From: Sue Howell
Sent: 05 November 2018 16:24
To: Planning.Responses
Cc: Anita Gardner; Michael Eastham
Subject: RE: Planning Consultation on: A/114/18/PL

APPLICATION **A/114/18/PL**

Site Address: Broadlees Dappers Lane Angmering BN16 4EN

Description of Works: Demolition & erection of 70 bed care home within Use Class C2 (replacing building 4 approved by A/27/16/PL), access, parking, landscaping and other associated works

Proposed landscape plan

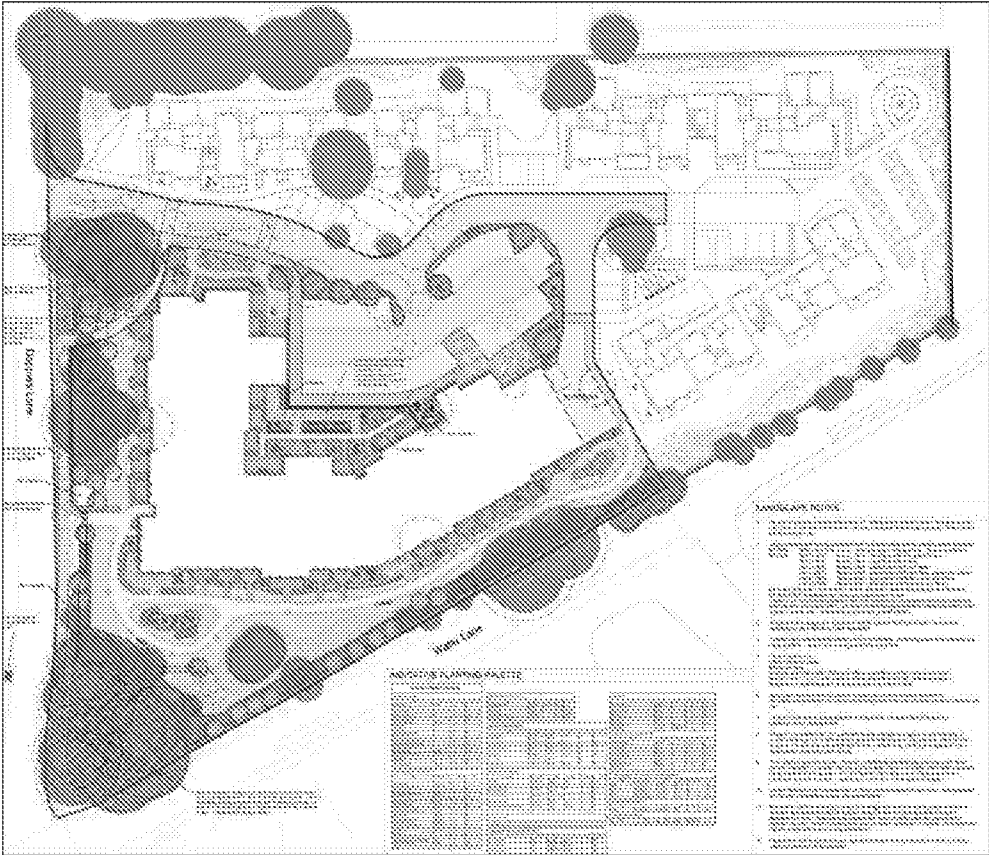
As this is a proposal for a development of sheltered apartments for the elderly there would be no requirement for play or play area contribution. However greening to soften the development would be required on a development of any kind.

Our SPG states that in the case of developments aimed at non-family dwellings, such as accommodation for the elderly, there will be the requirement for other forms of open space more appropriate to the needs of these or other groups of people. These areas need to be attractive, accessible and appropriately designed.

Whilst there has been a landscape plan produced Landscape Proposals Dwg no 101G this is an indicative layout which we would require to be submitted in detailed plan form listing species choice with specific quantities of each, with planting densities and size at time of planting. Planting beds and specimen shrubs have been indicated which will give an element of greening, these will need to be confirmed in order for the full picture to be seen and screening trees to be incorporated as appropriate in consideration of the surrounding properties. The communal courtyard patio should be stimulating and attractive particularly important for residents who may potentially be confined to these areas, the stimulation of what's outside should not be underestimated in providing a valuable and pleasant place to live.

My recommendation would be that the indicative scheme would appear suitable for use and location, I would however recommend that the above information is submitted for approval or conditioned with any decision.
